Re: Objection to State significant development application SSD-81426710 at 138 Maroubra Road, Maroubra

- 1.1 We refer to the notice of exhibition dated 20 November 2025 concerning SSD-81426710 at 138 Maroubra Road, Maroubra (**Proposed Development**).
- 1.2 The NSW Police Force (**NSWPF**) operates Maroubra Police Station on Lot 1 in Deposited Plan 504393, located at 136 Maroubra Road, Maroubra (**NSWPF Land**). The NSWPF Land adjoins the Proposed Development, being Lots 1 and 2 in Deposited Plan 506844.
- 1.3 The NSWPF has a number of concerns relating to the compatibility between the Proposed Development and the present and future use of the NSWPF Land.
- 1.4 The letter sets out the NSWPF's **objection** to the Proposed Development.

DRAWN BY	SCALE	SHEET SIZE	PRINT DATE
Author	1:100	A1	18/09/2025
DESCRIPTION			REVISION
ROOF TERRACE PLAN			5:10:08 PM
PROJECT No	DRAWING No	REVISION	
21_435	DA1.113	P

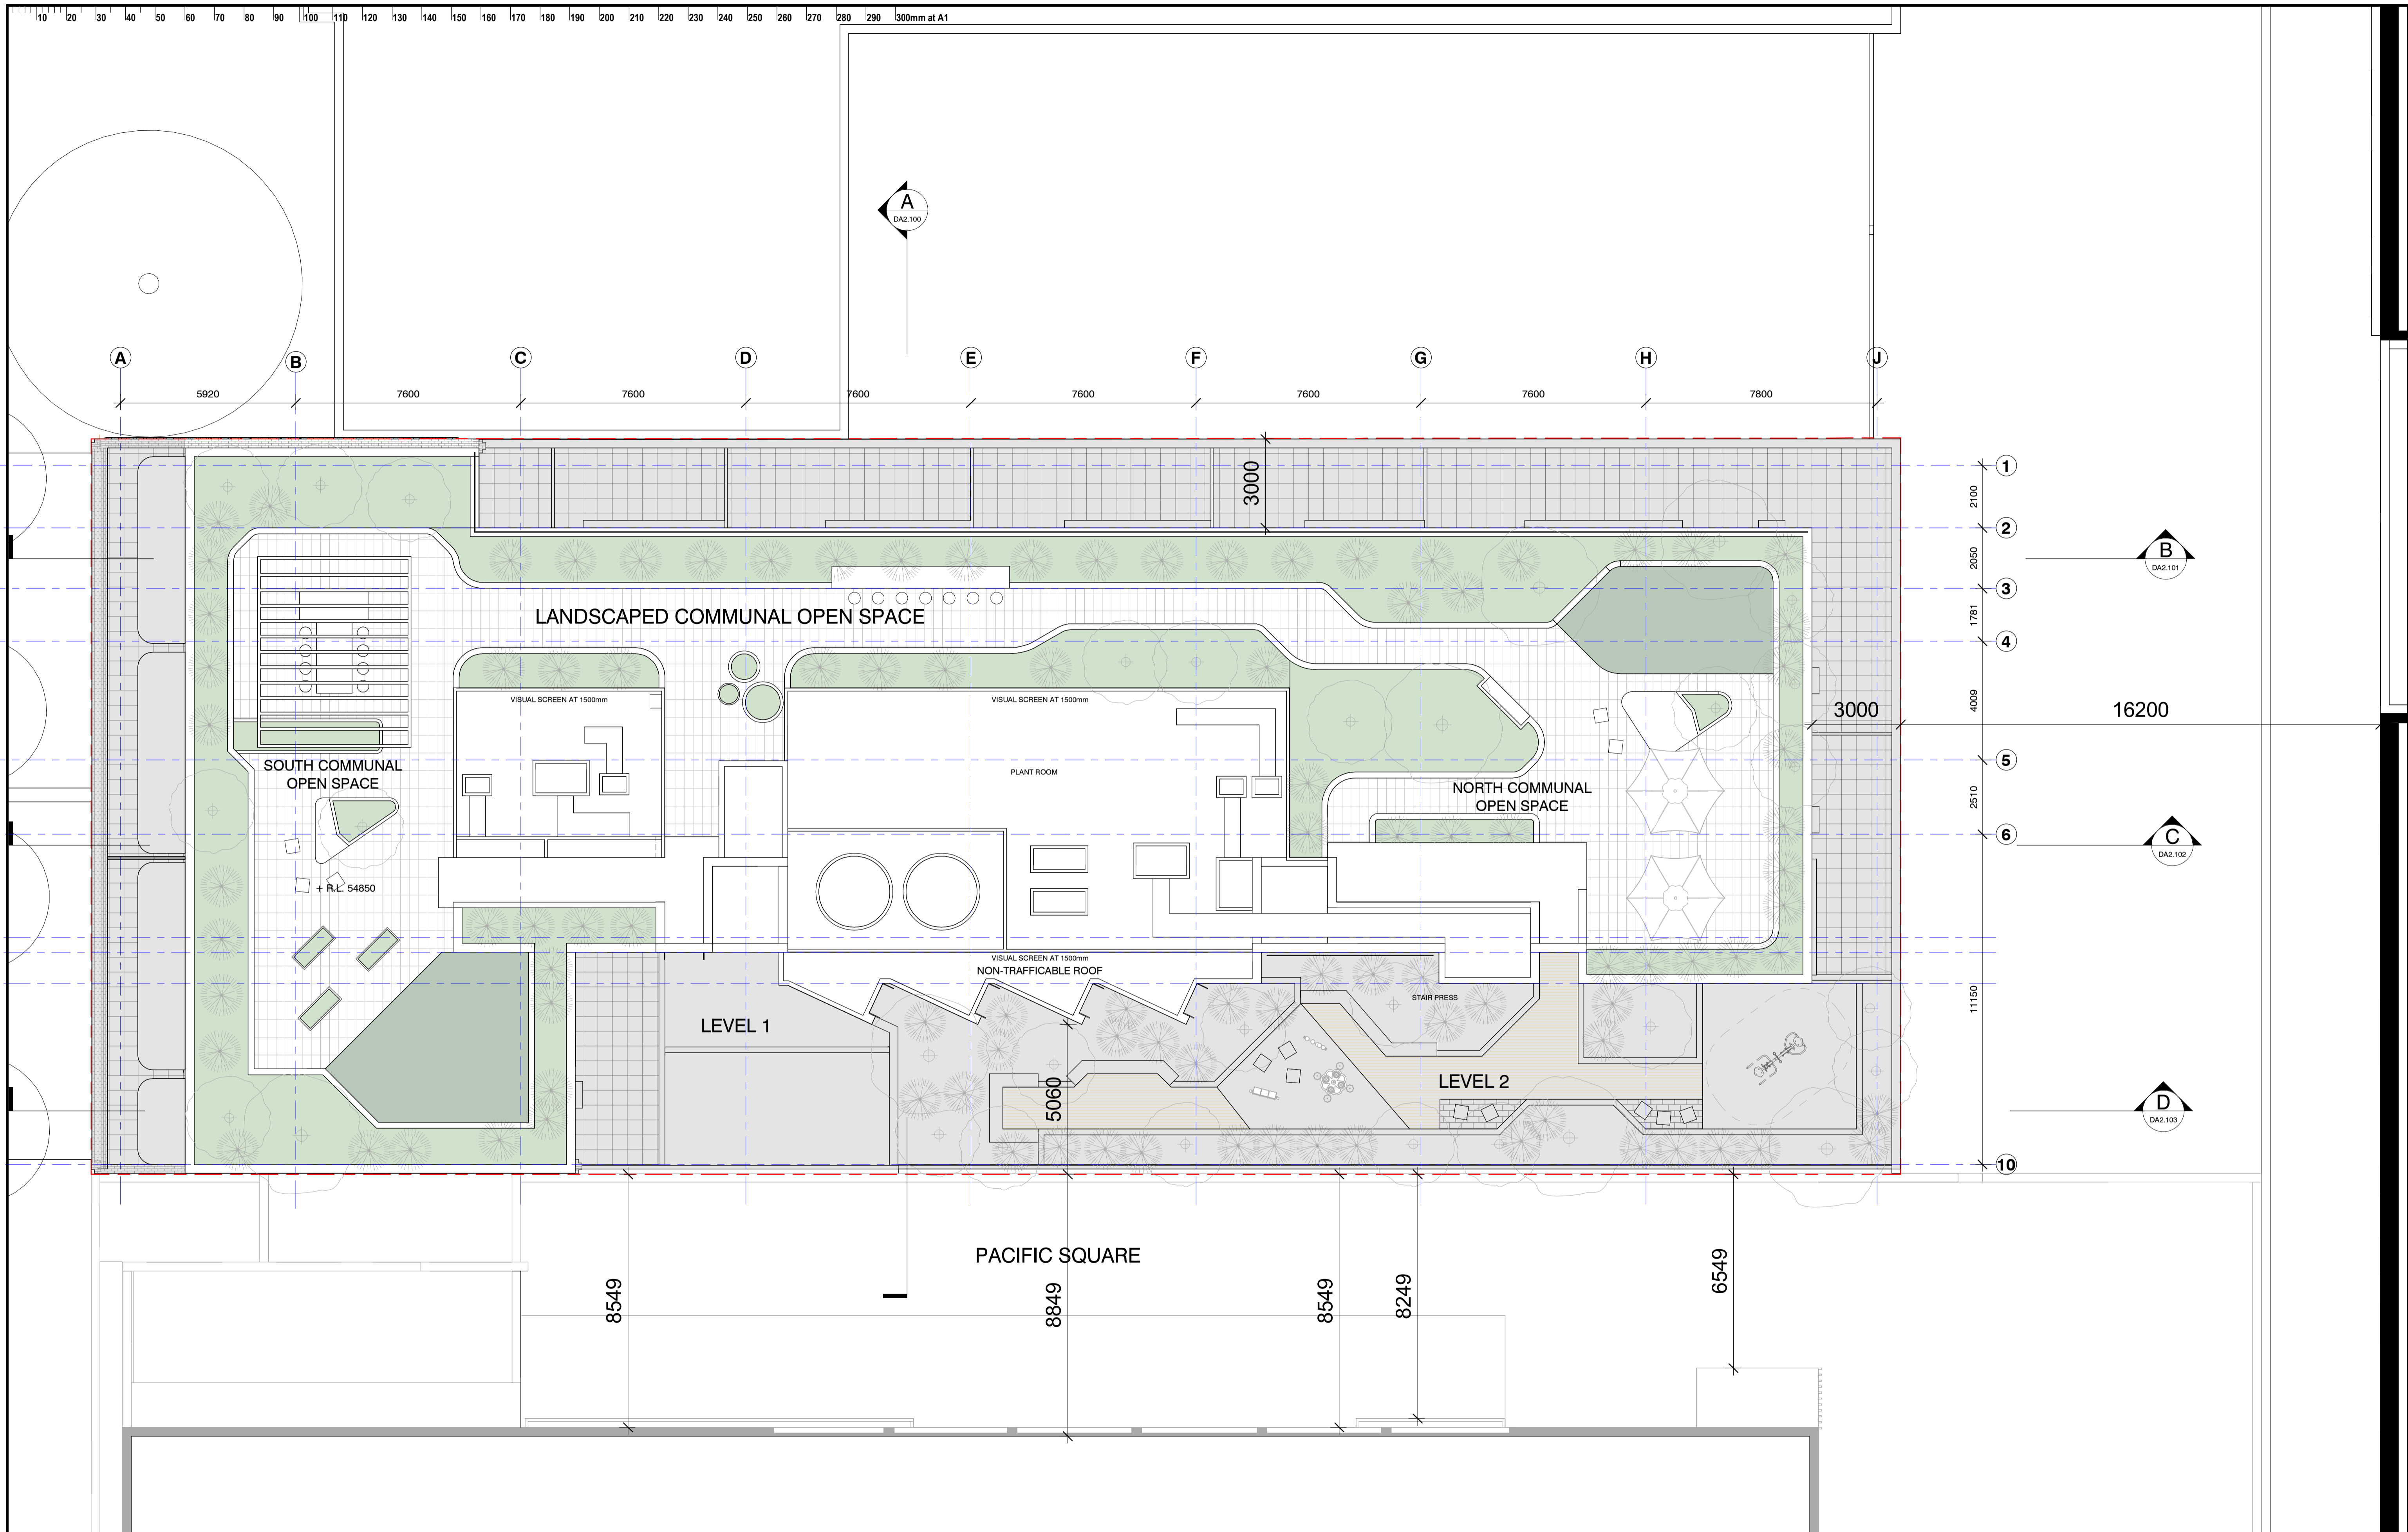
5.7 The Proposed Development includes a rooftop terrace with safety screens proposed along the northern and western boundary (Table A EIS Appendix C). The NSWPF considers the inclusion of the safety screens as essential to ensure the safety and privacy of police operations on the NSWPF Land. The NSWPF seeks additional information about the finish and treatment of the safety screens.

DRAWN BY	SCALE	SHEET SIZE	PRINT DATE
Author	1:100	A1	18/09/2025
DESCRIPTION			REVISION
WEST ELEVATION			5:15:36 PM
PROJECT No	DRAWING No	REVISION	
21_435	DA2.203	N

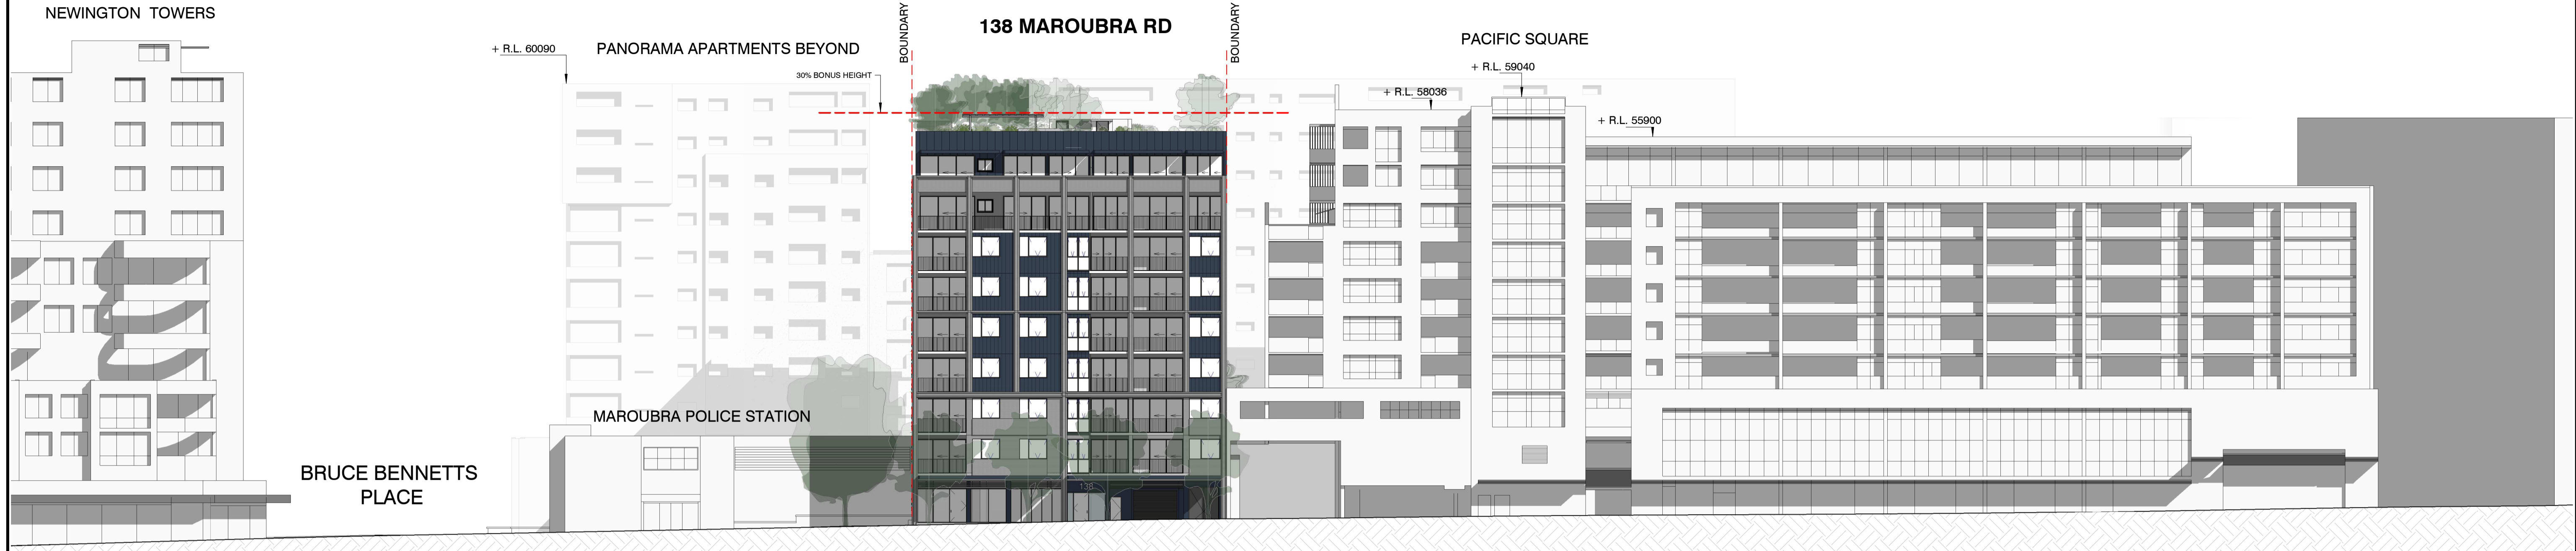
- 5.1 The Proposed Development comprises a 9-storey residential flat building with ground floor retail. There are 35 apartments on the western side of the Proposed Development that face the Maroubra Police Station.
- 5.2 There are five apartments on the western side of the Proposed Development on level 2 that have terraces which directly adjoin and overlook the NSWPF Land. The terrace wall is proposed to be 1.4m high as shown below.

- 5.3 It would appear that the individuals of the five apartments on level 2 can move out onto their terrace and view over the wall directly into NSWPF Land. This is unacceptable to the NSWPF as it poses a significant safety and security risk. The NSWPF considers that the 1.4m wall adjoining the NSWPF Land should be increased to improve the safety and security of NSWPF operations. The NSWPF also requires that the same visual treatments be installed on the western wall of the terrace (such as a fixed lattice or louvered treatment) of the terrace areas on level 2 to ensure that the safety and security of NSWPF operations is not compromised.
- 5.4 Above level two, there are 30 apartments on the western side of the Proposed Development that have balconies which overlook the NSWPF Land. The Proposed Development includes some

6.1 The western side of the Proposed Development includes a proposed set back of 3m from level 2 and above. There is no setback on the western side of the Proposed Development below level 2. The NSWPF considers that additional building set backs should be required on the western side of the Proposed Development to ensure it is compliant with the National Construction Code.
